Current Zoning: R-3 LWPA (single family residential, Lake Wylie Protected Area)  
Proposed Zoning: MX-2 Innov LWPA (mixed use, innovative, Lake Wylie Protected Area)

Approximately 43.72 acres located on the south side of Mt. Holly-Huntersville Road and north side of Interstate 485, west of Oakdale Road.

The petition proposes a residential community containing a maximum of 322 residential units. The unit mix could consist of single family detached and/or single family attached dwelling units and /or multi-family attached (triplexes) dwelling units with innovative standards.

RZP-2022-089

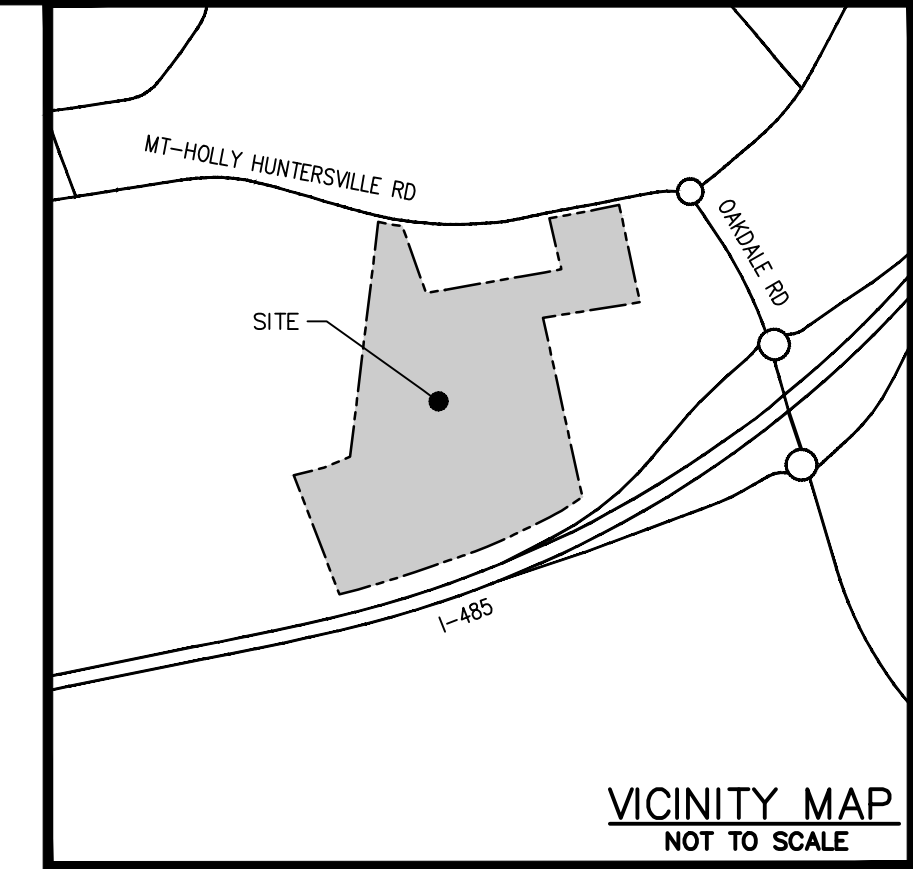
1. ~~Add a conditional note committing to the construction of each public roadway. Identify each roadway as U-03 on the site plan and in the conditional note.~~ Addressed
2. ~~Site plan and conditional note revisions are needed to show turn lane improvements. The site plan shall label and dimension the components of the turn lane. Add a conditional note committing to the turn lane improvements. Coordinate with NCDOT on turn lane storage length requirements.~~ Addressed
3. ~~A site plan notes specifying that all transportation improvements will be approved and constructed before the site's first building certificate of occupancy is issued as needed. The petitioner may phase transportation improvements if said improvements and phasing are explicitly described in site plan notes.~~ Addressed

5. ~~Revise site plan to construct a 12-foot multi-use paths on Mt Holly Huntersville Road. The site plan shall label and dimension both items from the back of curb and gutter and road centerline. The entire facility must be outside of the right of way and within a public access easement. Add conditional note committing to construction and maintenance of the 12-foot multi-use paths on Mt Holly Huntersville Road.~~ Addressed

6. ~~Remove garages.~~ Addressed
7. ~~Remove perpendicular parking from public streets. Parking along public roadways shall be parallel parking as shown in previous submissions. Public streets should be constructed to CLDSM standards including design of on-street parking and sidewalk.~~ Addressed

8. ~~Site plan and conditional note revisions are needed to show turn lane improvements as outlined above on the site plan. The site plan shall label and dimension the components of the turn lane. Add a conditional note committing to the turn lane improvements. Coordinate with NCDOT on turn lane storage length requirements.~~ Addressed

9. ~~Label and dimension the curb and gutter from the centerline for each road on the site plan.~~ Addressed
